CITY OF PORTLAND

BUILDING PERMIT

Located At 1124 FOREST AVE

Job ID: 2012-04-3731-ALTCOMM

Proposed Deck

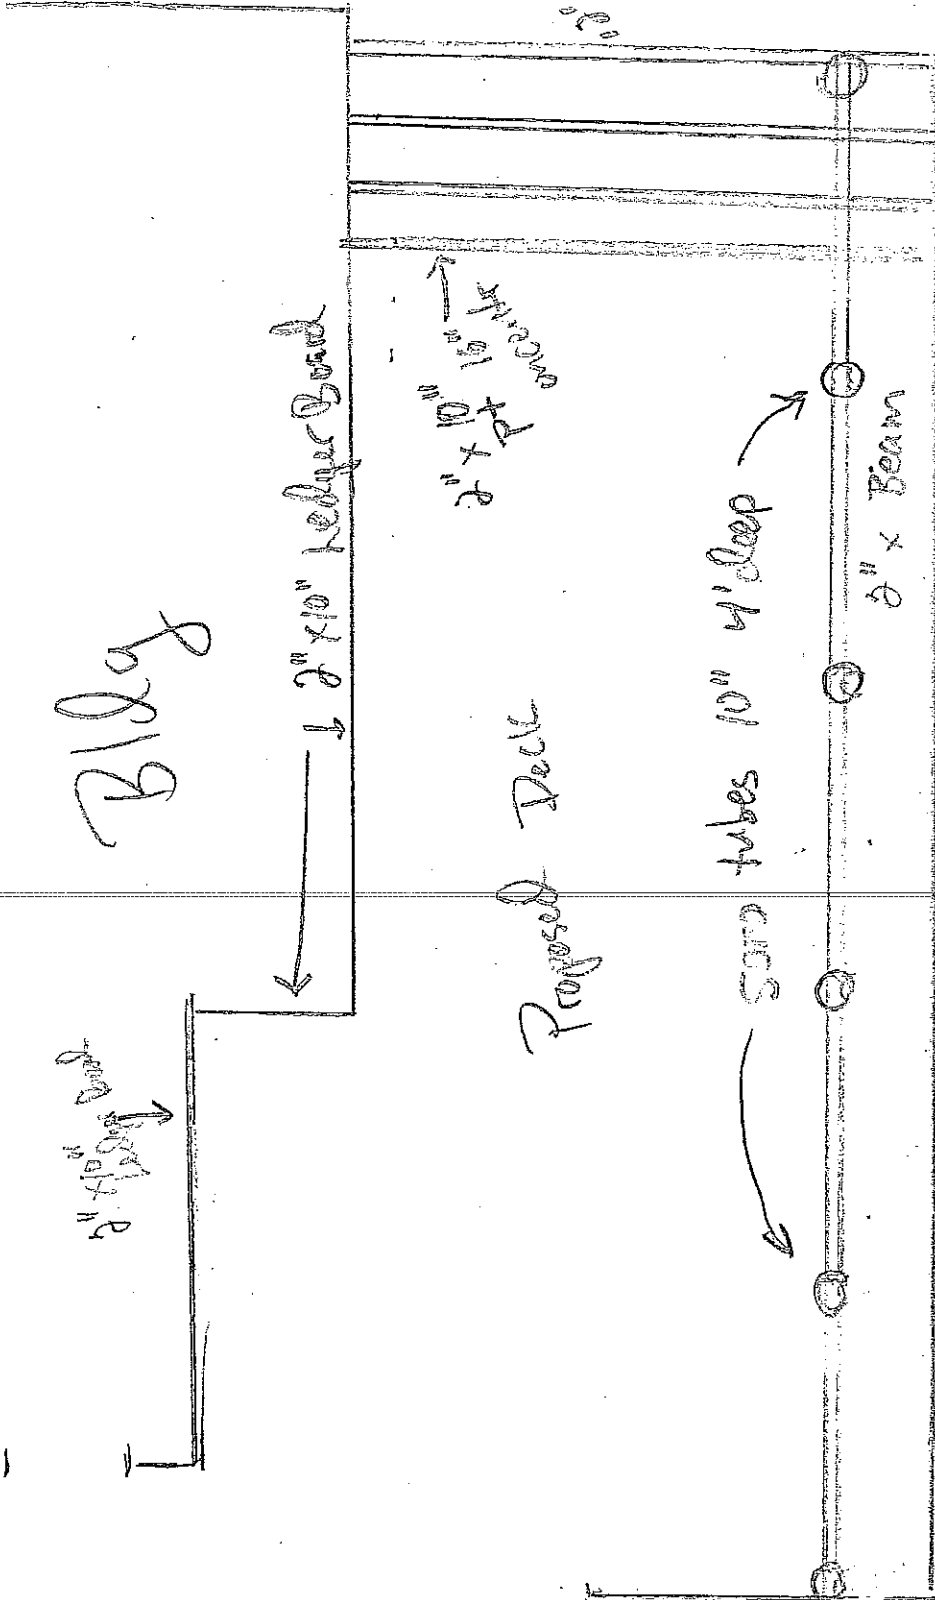
2. Permit approved based on the plans submitted and reviewed w/owner/ contractor, with additional information as agreed on and as noted on plans including, 2-2x10 deck beam, 18" cantilever.

3. Details for the transition from the deck to the existing asphalt ramp shall be submitted for review prior to constructing.
4. Separate permits are required for any electrical, plumbing, sprinkler, fire alarm, HVAC systems, heating appliances, including pellet/wood stoves, commercial hood exhaust systems and fuel tanks. Separate plans may need to be submitted for approval as a part of this process.

5. The following Table and Figure provide a guide to the ledger attachment bolt spacing schedule and the lateral deck attachment in 2 locations as agreed upon with the contractor, R. Leo Richardson. Deck lateral attachment detail to be submitted.
